Mr Saul Moran
Development Manager
ARNCLIFFE EDEN PROPERTY PTY LTD
173 SUSSEX STREET
SYDNEY NSW 2000

27/04/2022

Eden Street, Arncliffe Mixed Use Redevelopment (SSD-11429726)
Request for additional information

4 GFA DIAGRAM - LEVEL 18 (TOWER C LEVEL 17)
1 : 600

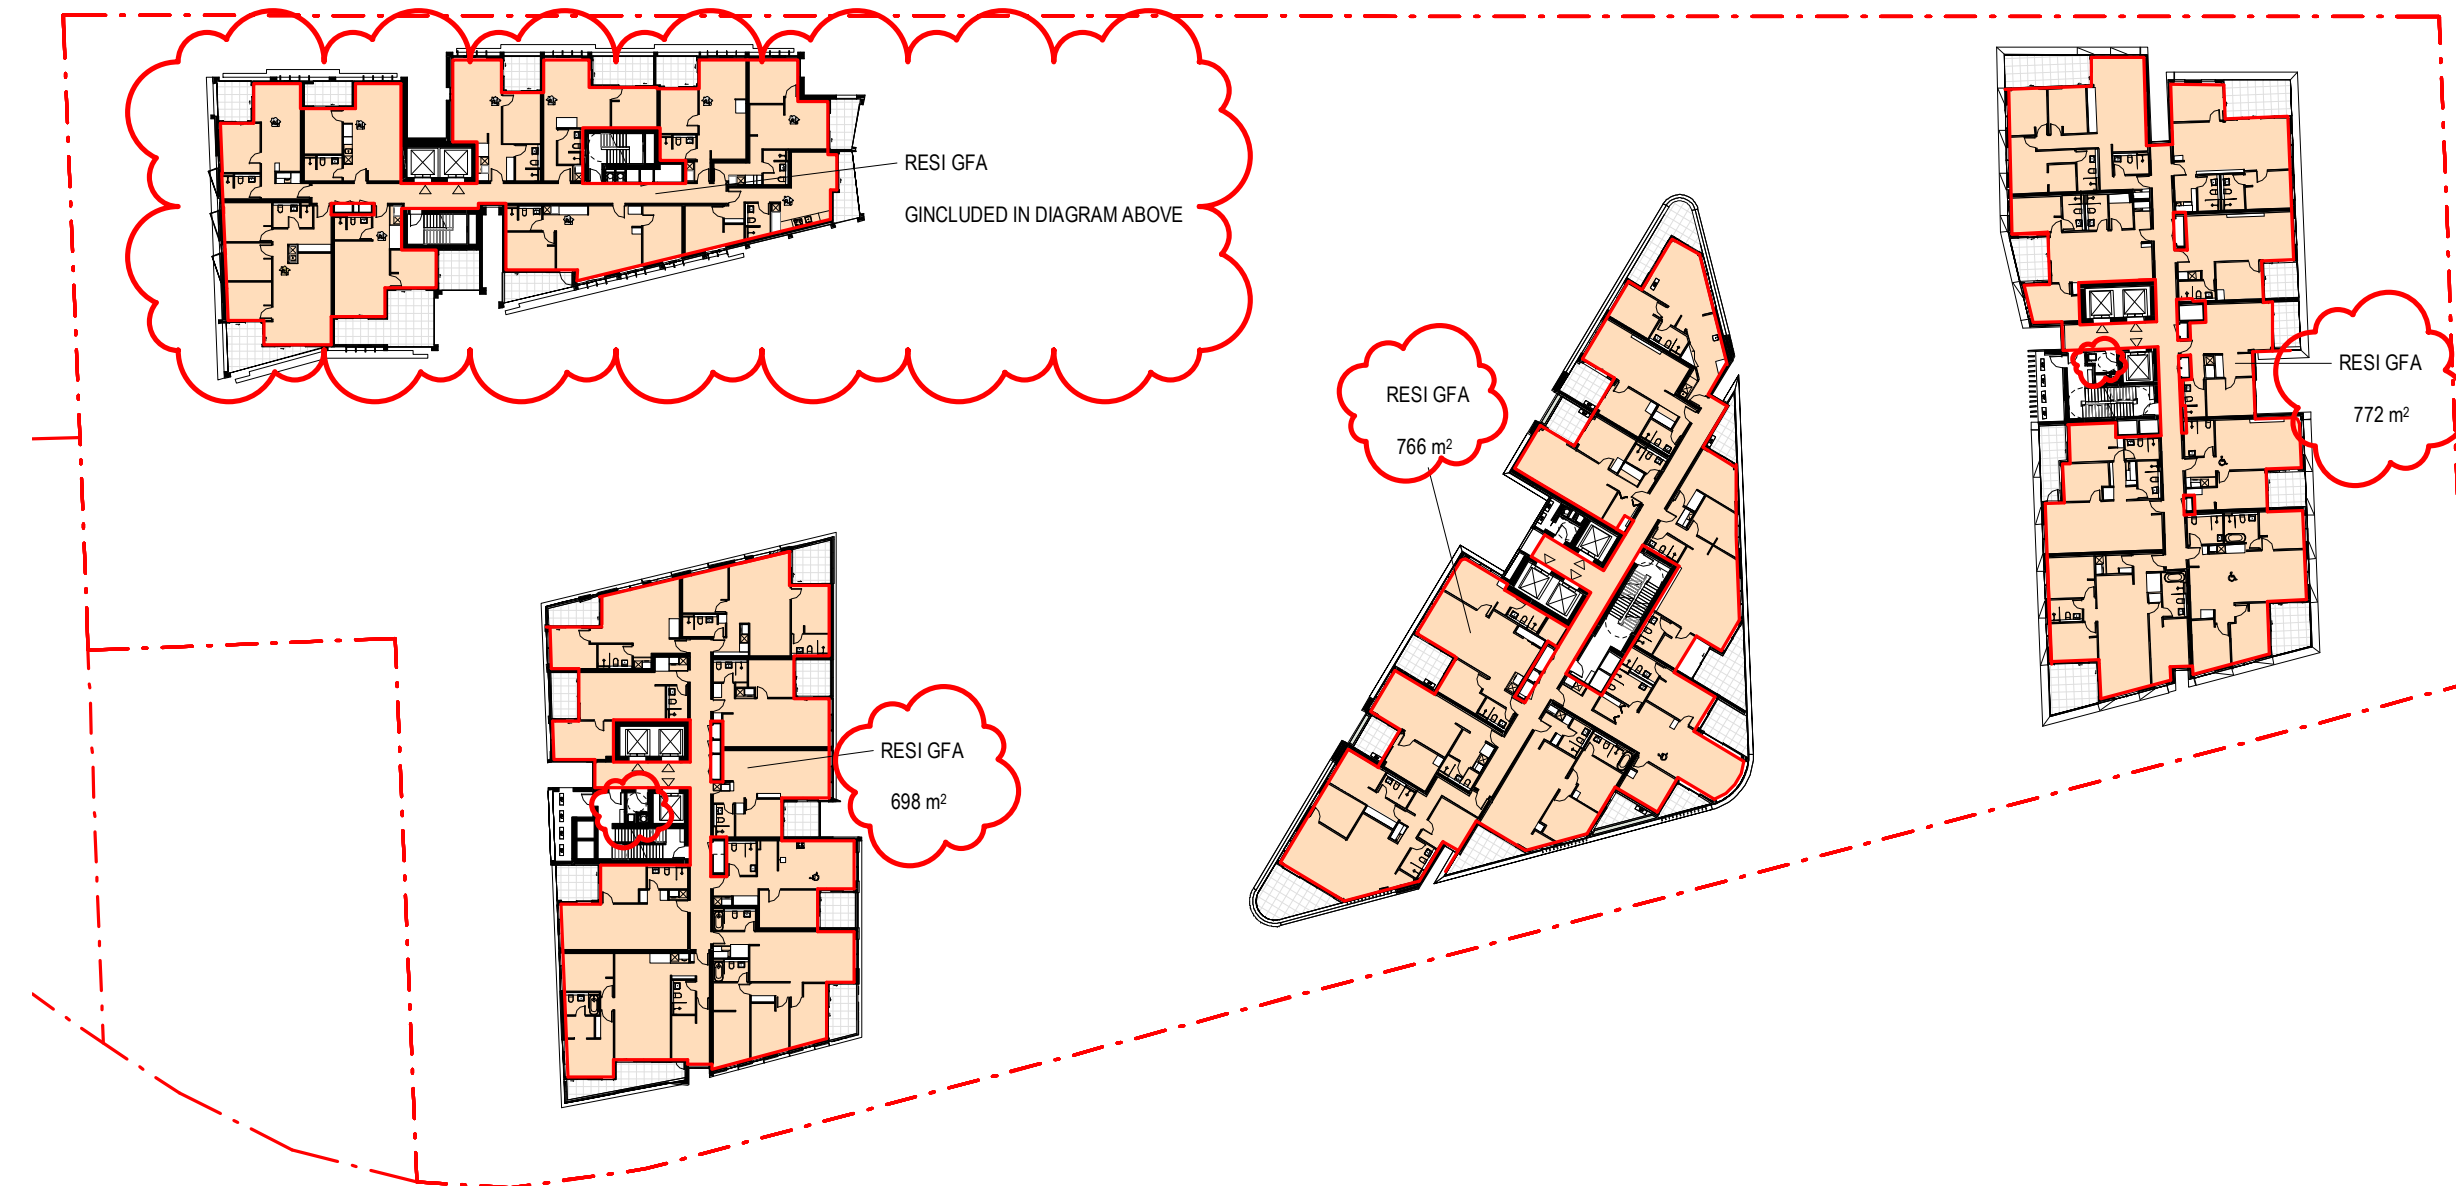
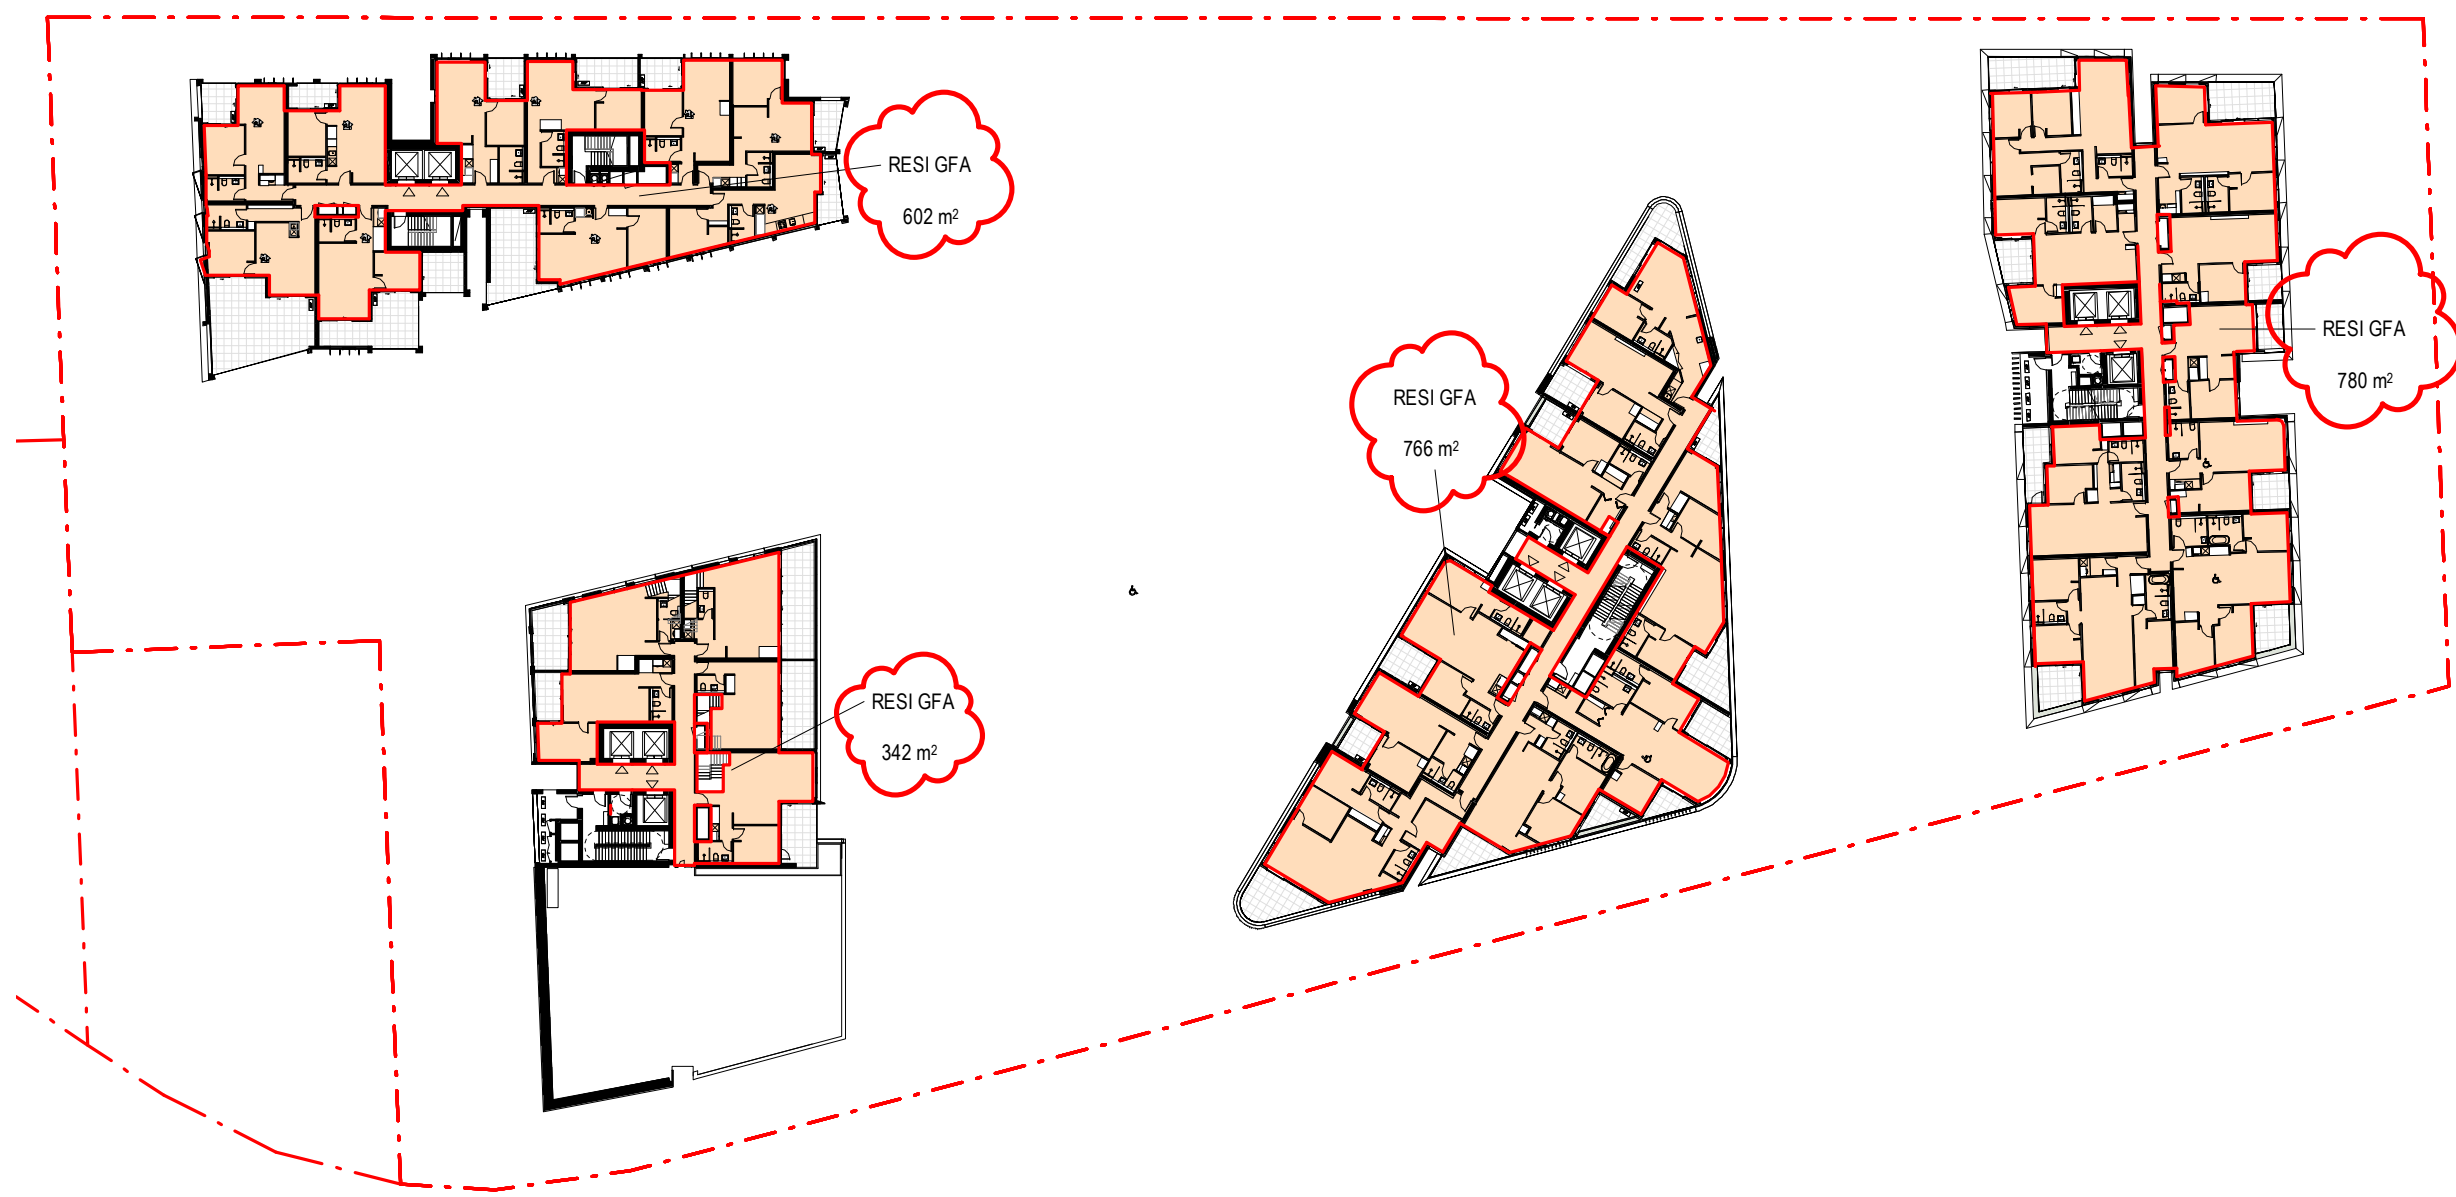
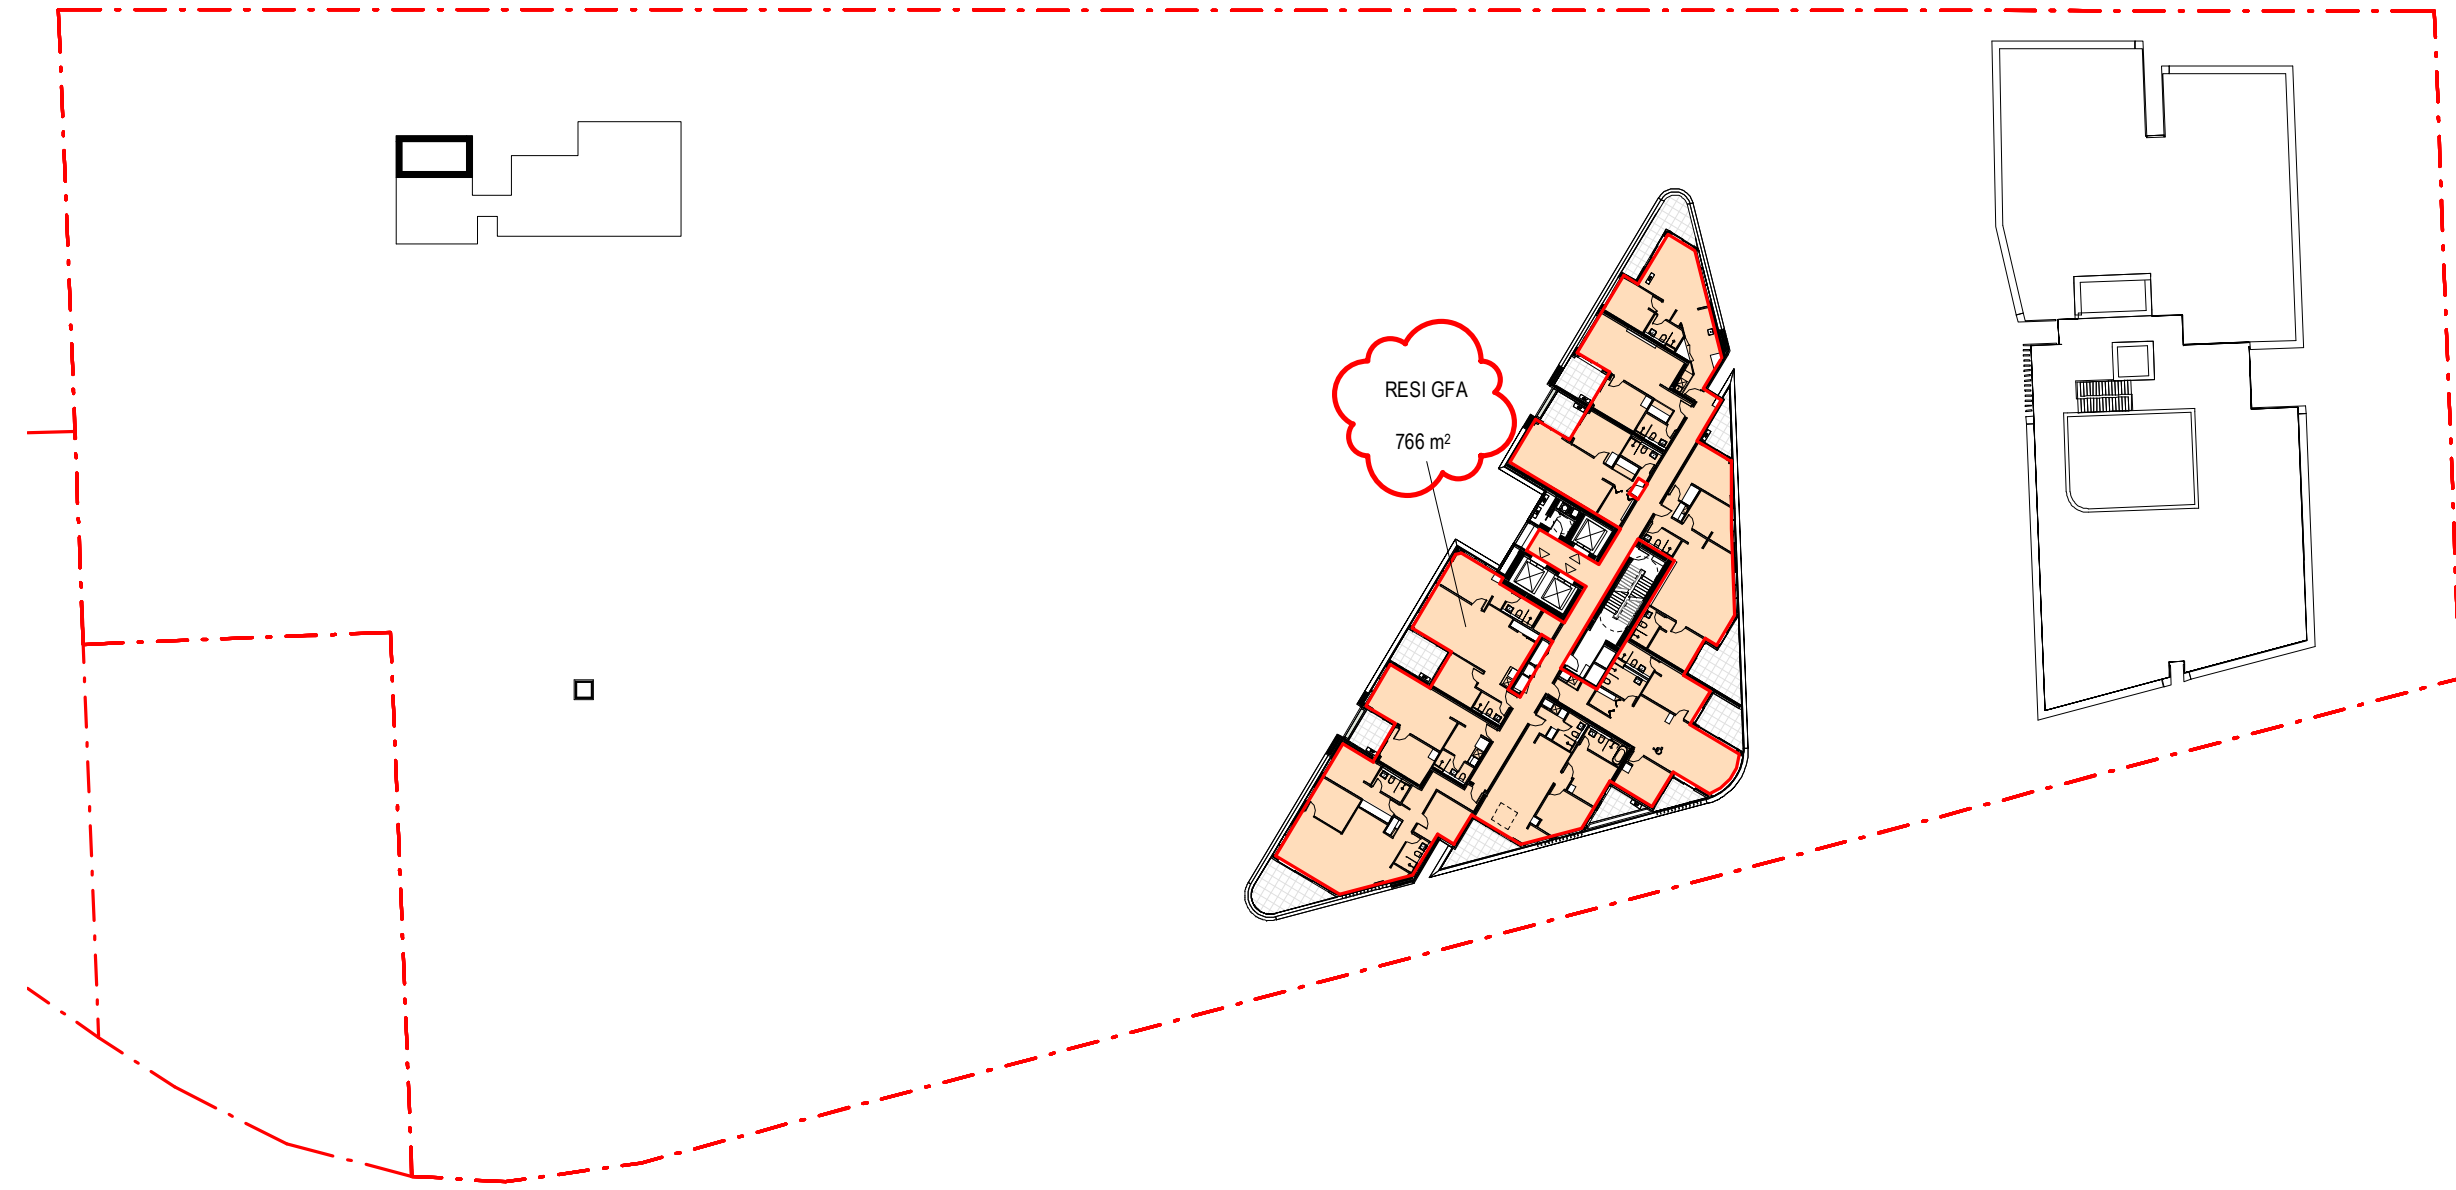
- An updated 4.6 variation request accurately reflecting the proposed GFA.
- Clarification and further justification for the proposed 850mm boundary setback to the neighbouring properties at 52 Eden Street, 7 Forest Road and 181 Princes Highway. I note that the wall adjacent to this boundary is not a party wall and the justification that it ensures no constructability or structural concerns for future development is unclear. Consideration should also be given to how the wall itself and the area between the building and the boundary would be treated, accessed and maintained.
- Confirmation on the plans sought for approval including a full consolidated set of architectural, landscape and any other plans reflecting the proposal as amended by the RtS and Responses to the Department's RFIs.
